Proposal: Discharge of Condition 5 (doors and windows) of 21/02366/F

Document titled Windows & Doors (Condition 05) by Squire & Partners reference 20064 dated September 2022

Fig. 1 & 2 - Photos of the window sample in a Vulcan Black finish

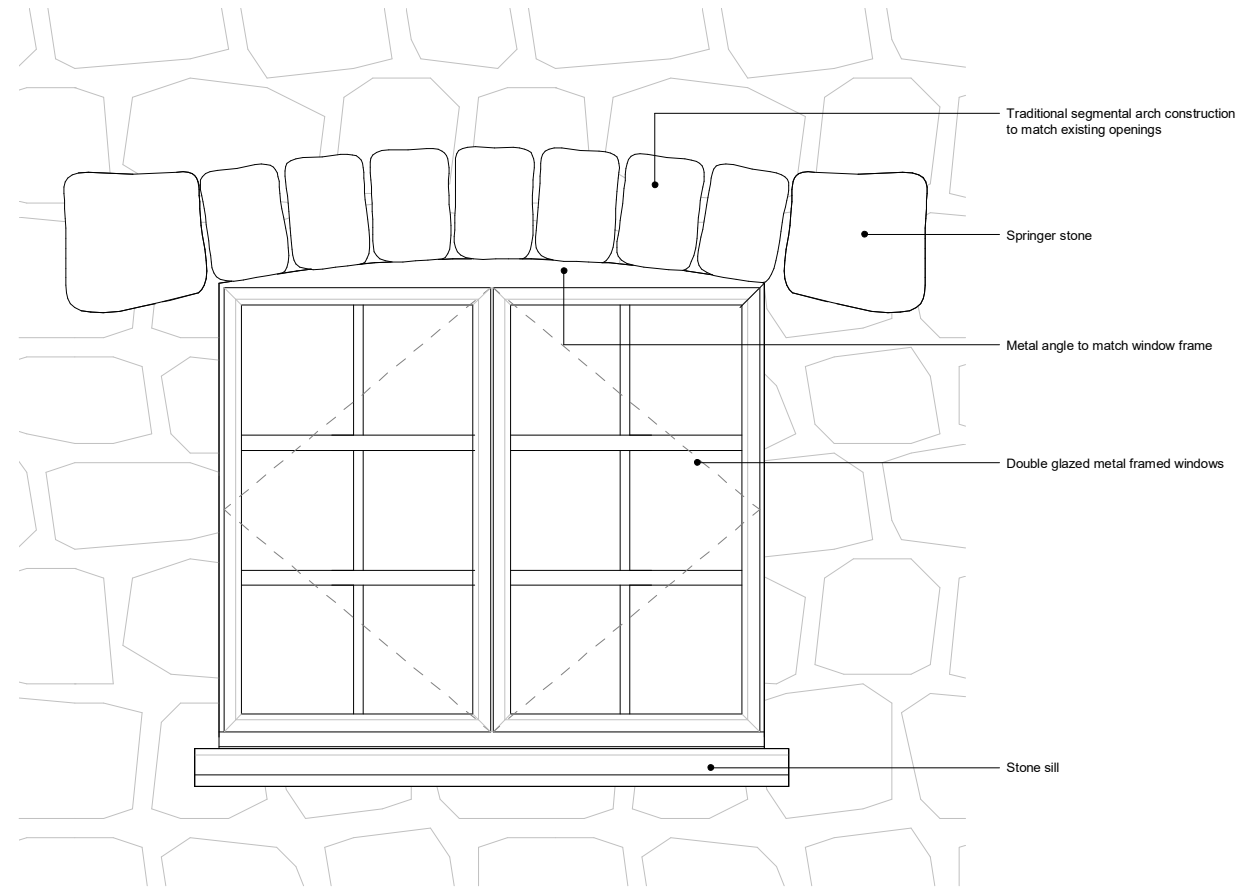
- 5.1. The details submitted with this application show the use of metal casement windows and doors would be made with a Vulcan Black finish. This material would appear black, as illustrated in the CGIs which formed part of the supporting material on the planning application for the approved scheme.

5.2. The use of the black frames against the warm limestone would appear as a contrast to the normal white which is the normal colour in this village. However, it is clear that there is a variety of colours of window and doors in the village including dark brown, grey and light blue. Furthermore, as the dwelling is set back into the site and not clearly visible from the public highway the use of black is considered acceptable and would complement the dark blue / grey slate on the roof. Also, the Conservation Officer has no objections.
